Subject: FW: Y/101/19/DOC - Yapton View (land off Burndell Road), Yapton, BN18 0HW

From: Kate Giddings <kate.giddings@arun.gov.uk>
Sent: 18 December 2019 13:09
To: Simon Davis <Simon.Davis@arun.gov.uk>; Planning.Responses <Planning.Responses@arun.gov.uk>
Subject: RE: Y/101/19/DOC - Yapton View (land off Burndell Road), Yapton, BN18 0HW

2.3 Root barrier installation works

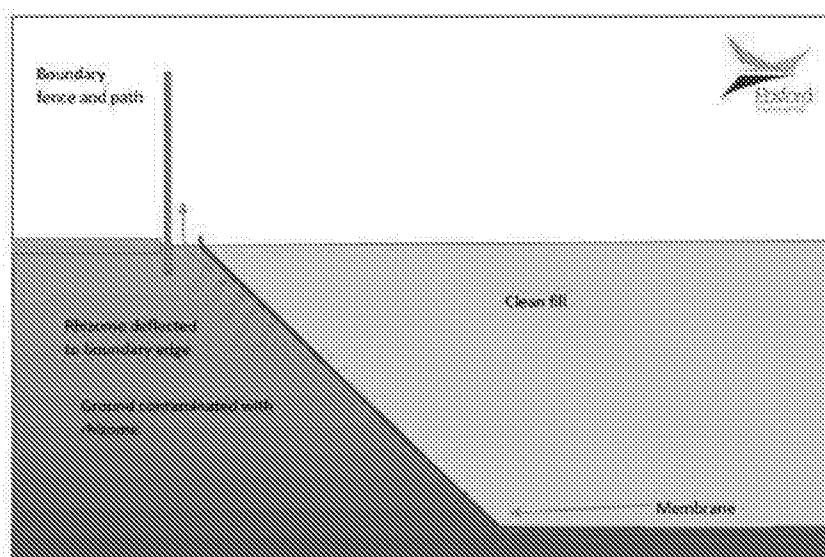
Thank you for the additional documents; the majority seem satisfactory but please may the applicant confirm whether the root membrane also acts as the visible deter-to-dig membrane (as per Geo-Environmental's RSVP) across this area of the site?
